Current Zoning: N1-A (neighborhood 1-A)  
Proposed Zoning: UR-2(CD) (urban residential, conditional)

Approximately 4.2 acres located on the north side of Galloway Road, east of Mallard Creek Road, and west of Garrison Road.

The petition proposes a residential community of up to 28 single-family attached dwelling units.

REZONING SITE PLAN

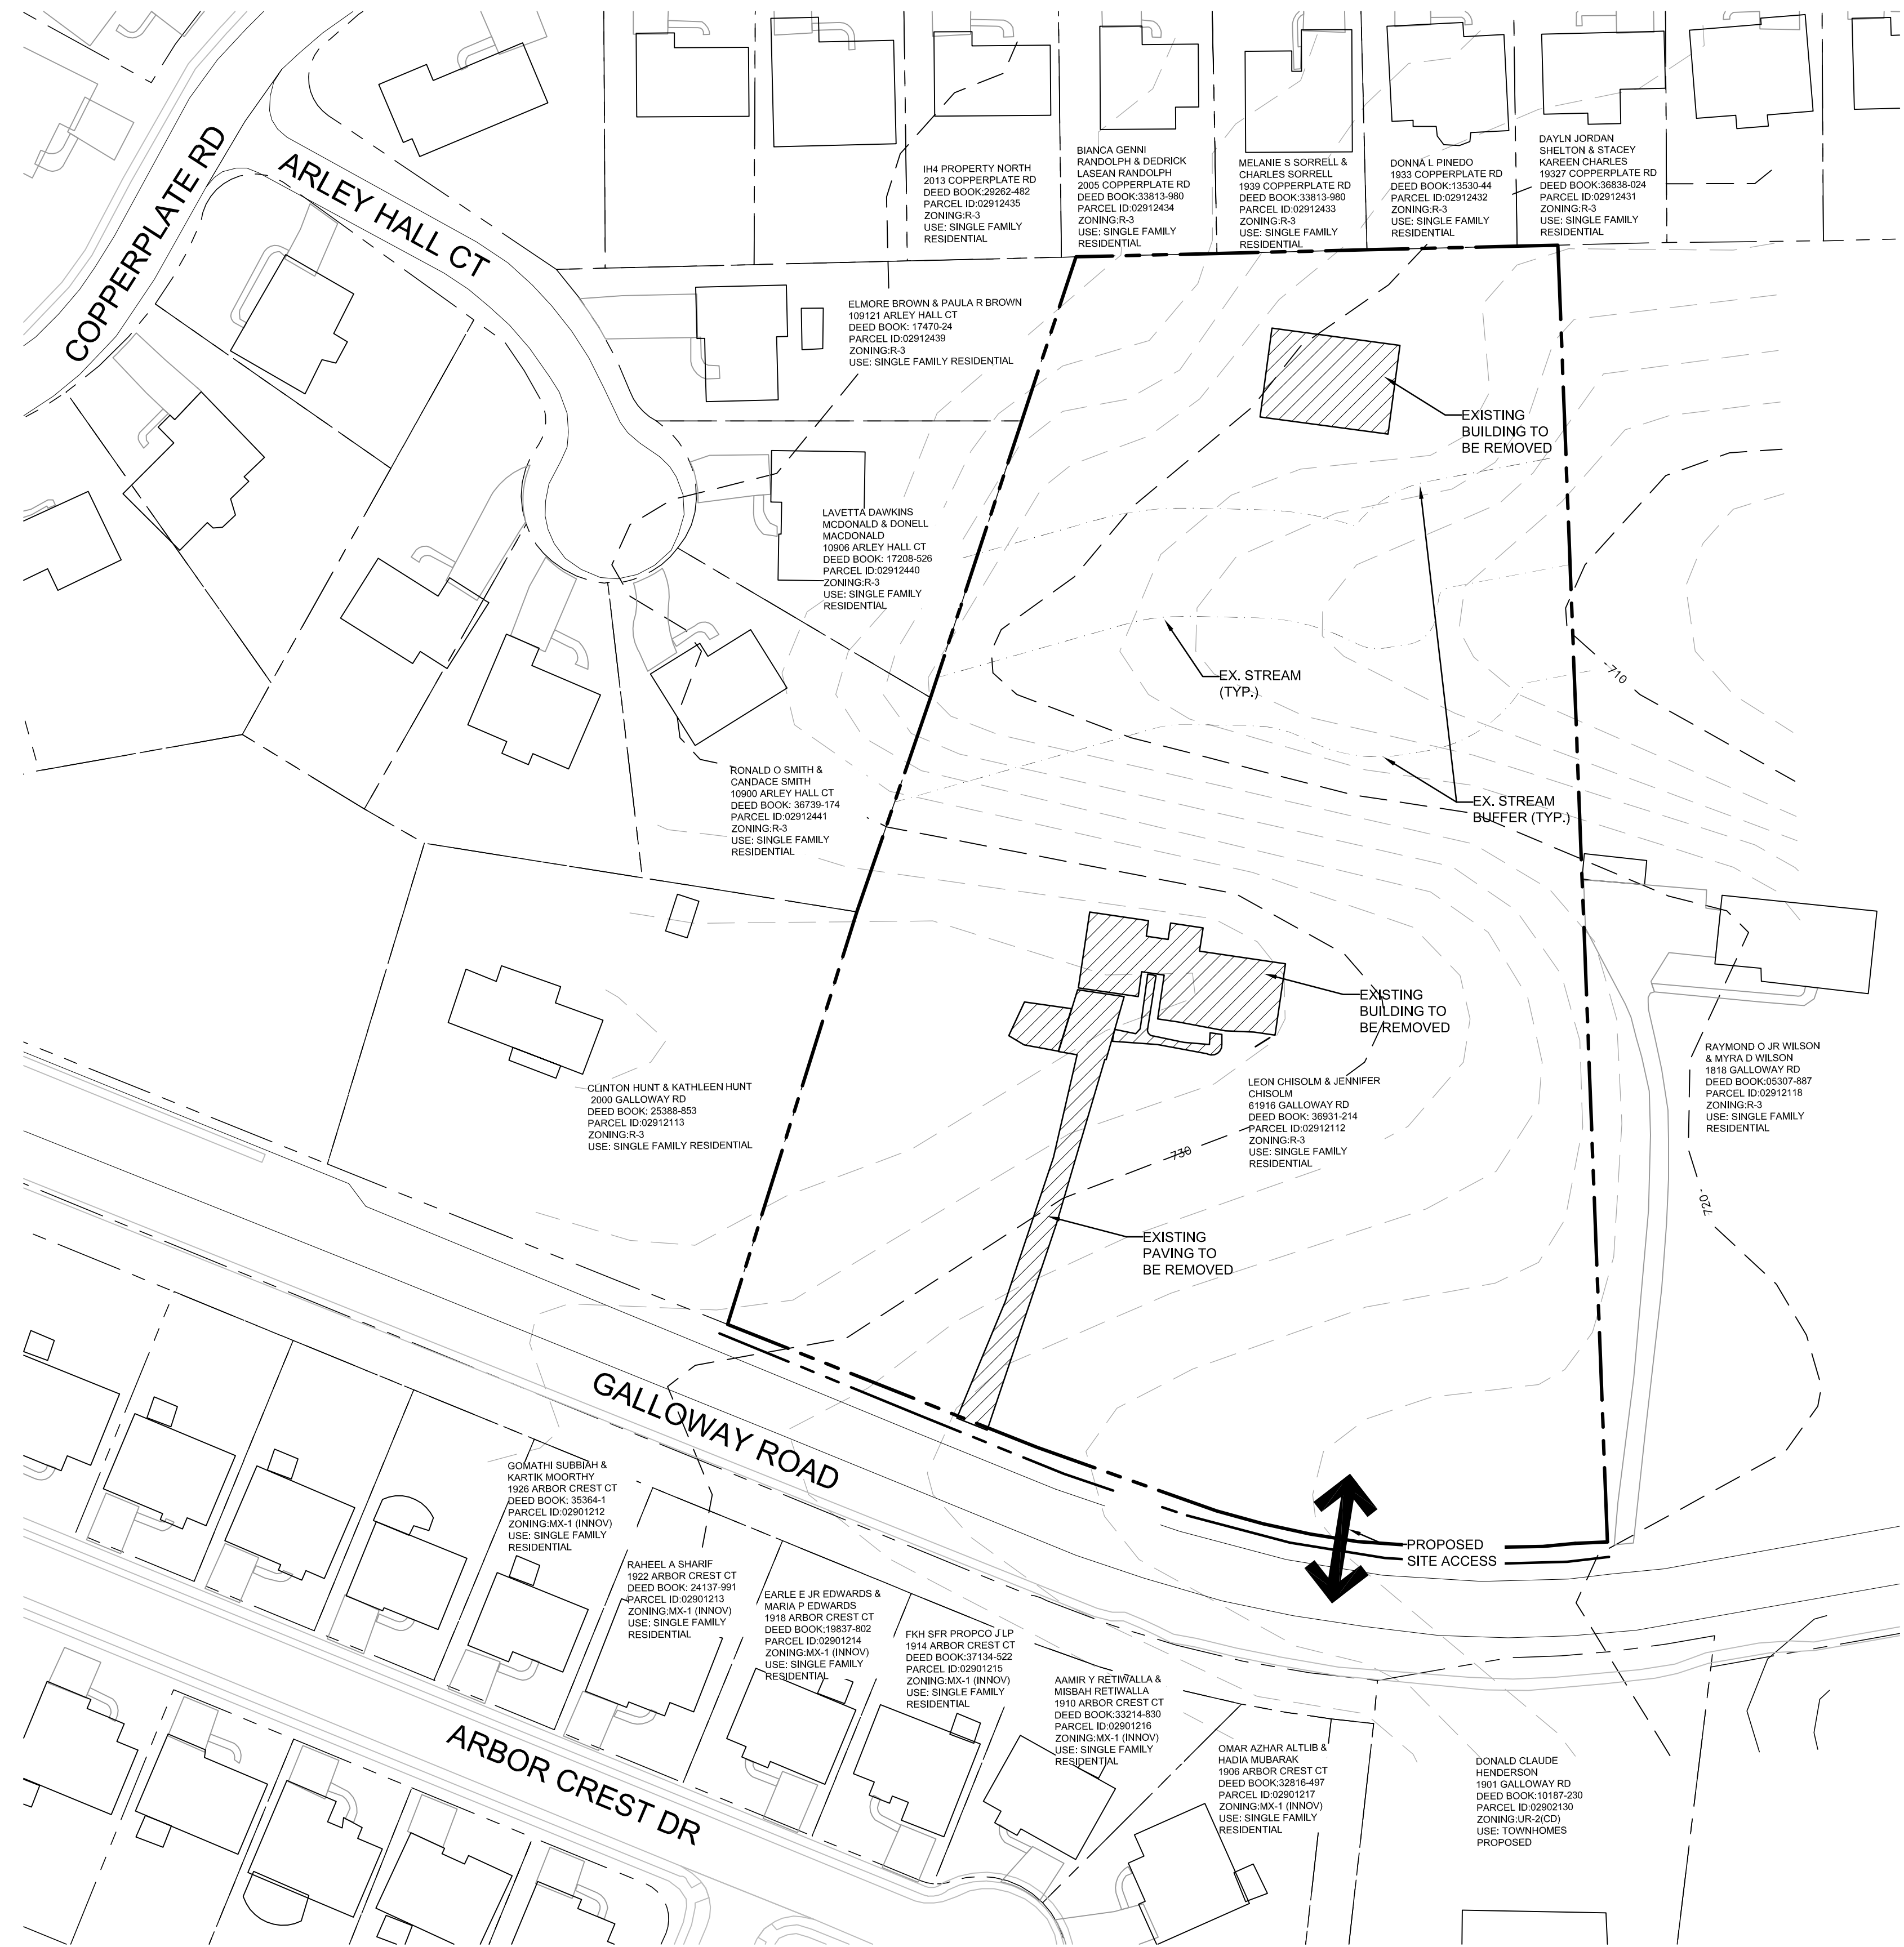
1. Remove "visible from", changing to "proposed along" to read: "Garage doors proposed along public..." for architectural note 8.
2. The setback in the site data table says 35' from BOC. please show correct setback.
3. The rear yard in site data table say 10'. Please add or 20' as shown.
4. Change the height in site data table to say 40', with allowance up to 48' per 9.406(2)(a)
5. Change architectural note 5 from 4 units to 3 units fronting Galloway Road.
